Landscape Plan_v1.pdf Markup Summary

OFFICE WAREHOUSE
 DEVELOPMENT PLAN MINOR AMENDMENT
 9495 PEACEFUL VALLEY ROAD
 COLORADO SPRINGS, COLORADO 80908

SITE /LANDSCAPE PLAN

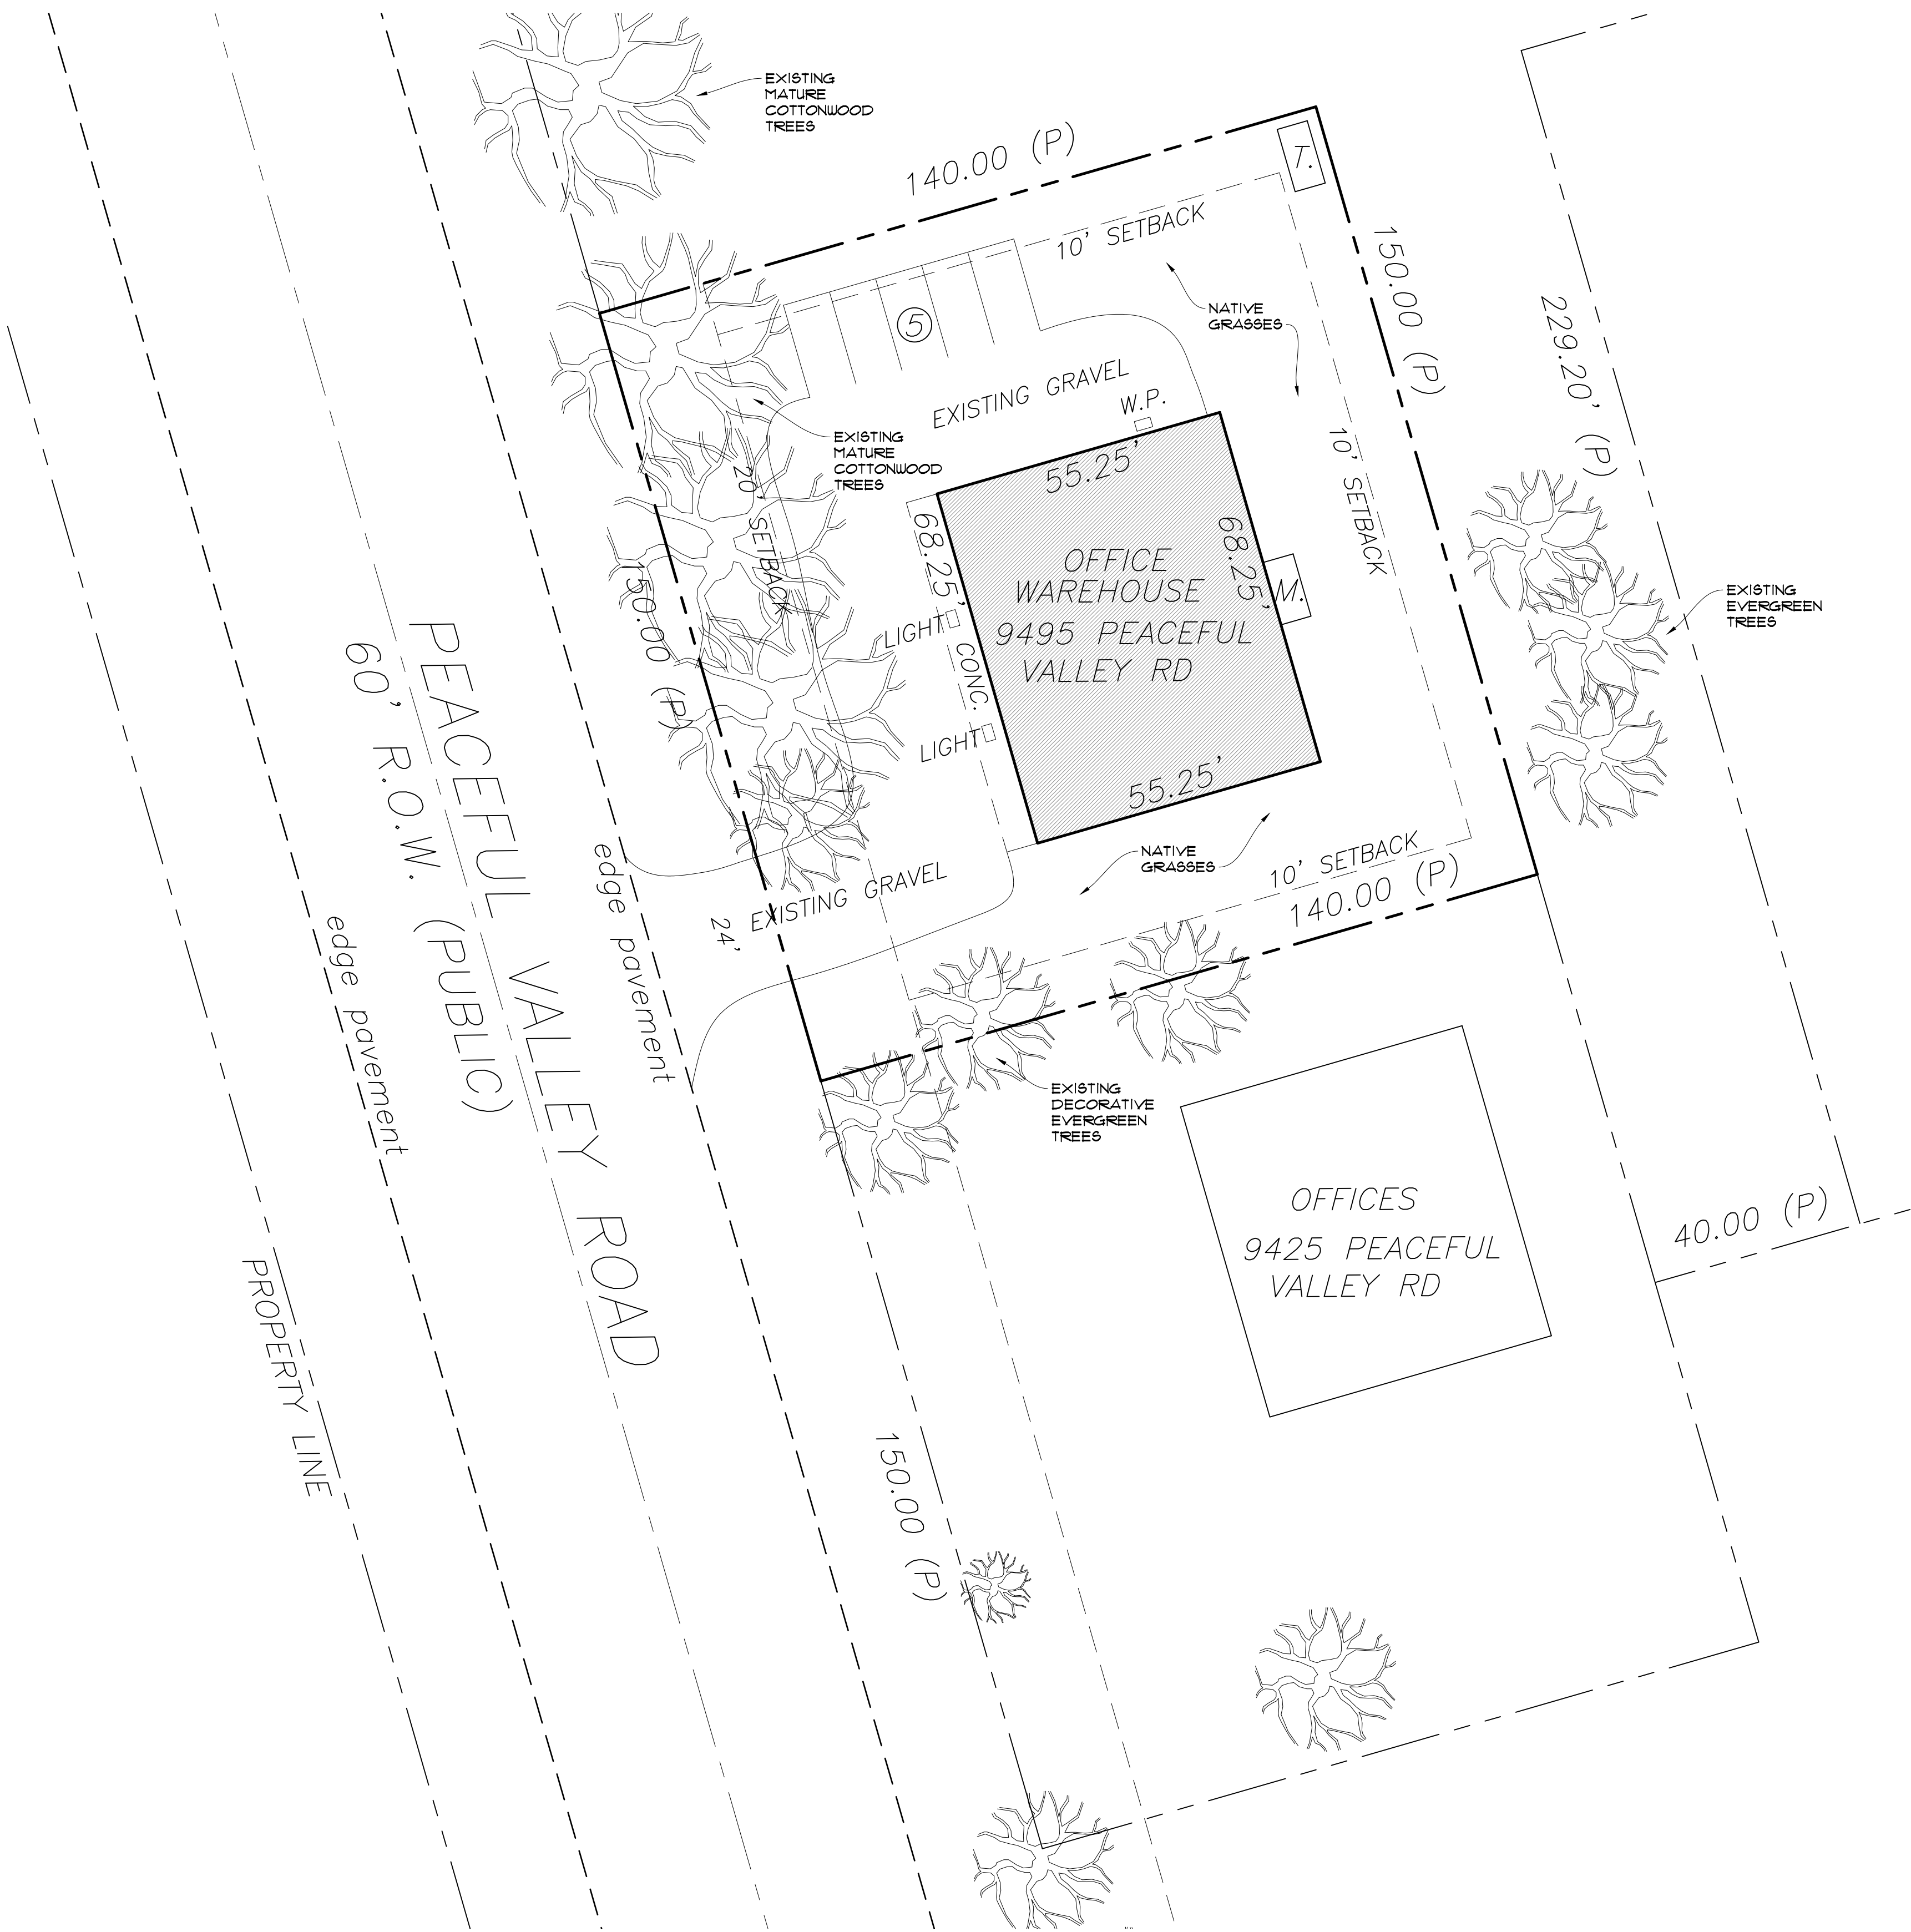
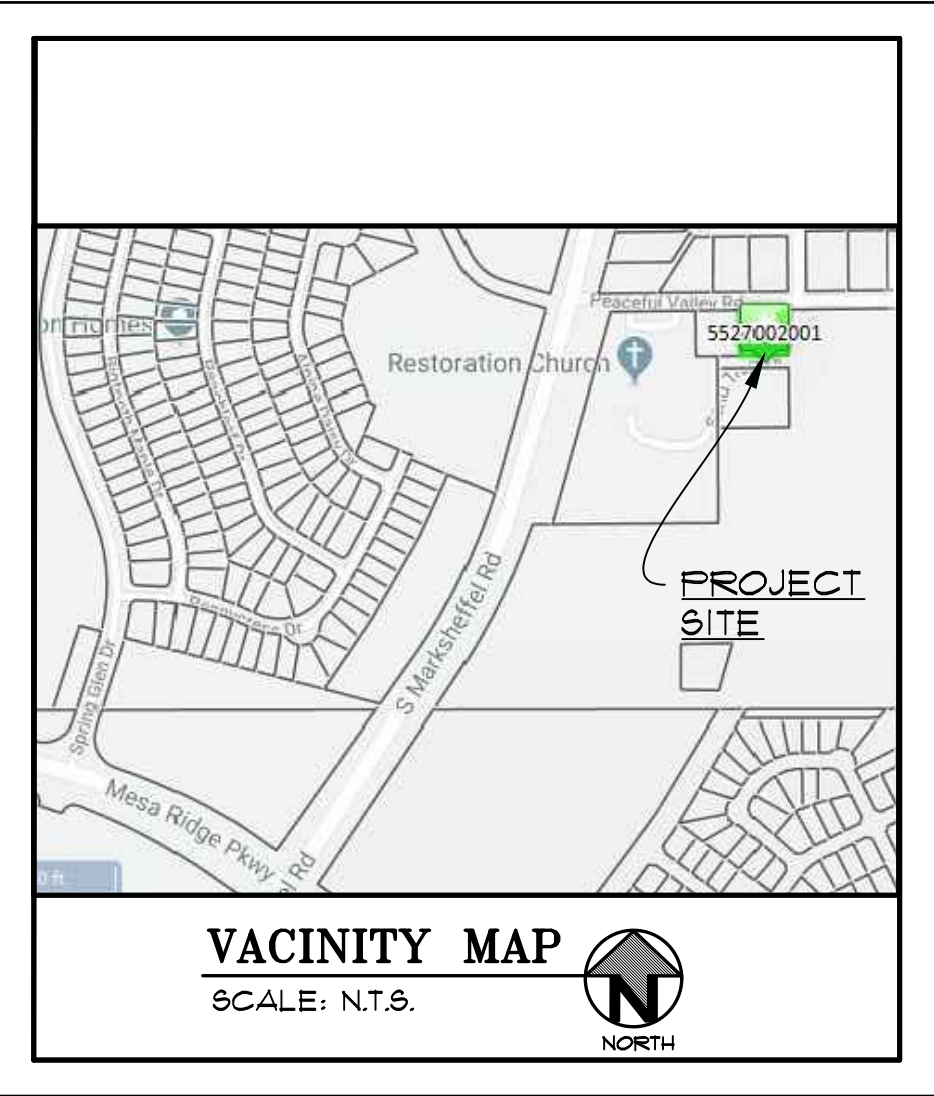
Cannot be considered part of landscaping plan.
Trees are on adjacent parcel.

Cannot be considered part of landscaping plan.
Trees are on adjacent parcel.

Cannot be considered part of landscaping plan.
Trees are in ROW.

Landscaping details required - see 6.2.2 in the land development code
